Planning Inspectorate

Our ref: XA/2025/100412/01

One Earth Solar Farm – Development Consent Order Application

Registration as Interested Party and Submission of Written Representations

Figure 1: Survey locations

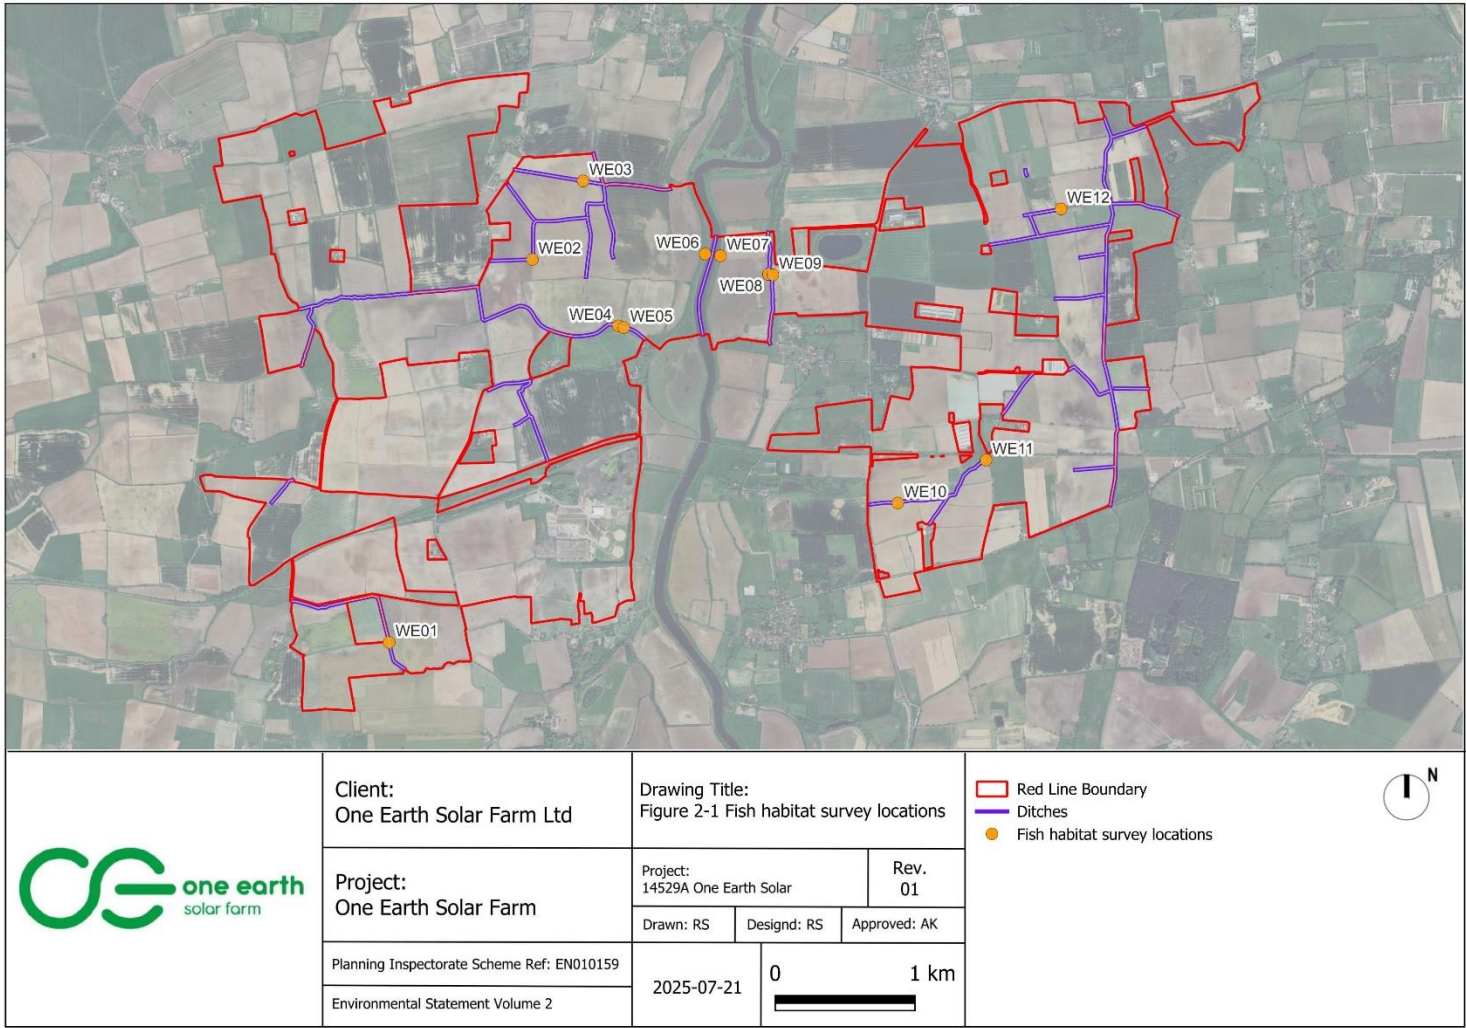
Ecological Assessment	Not Agreed	Not Agreed	Not Agreed	Not Agreed	EAFBG-001 - Fish species missing
-----------------------	------------	------------	------------	------------	----------------------------------

only river lamprey and sea lamprey have been assessed.

EAFBG-002 - Protected fish species have not been included within Table 3-1 Extended Habitat Survey.

EAFBG-003 - No fish species are included within the desk study (appendix 6.2).
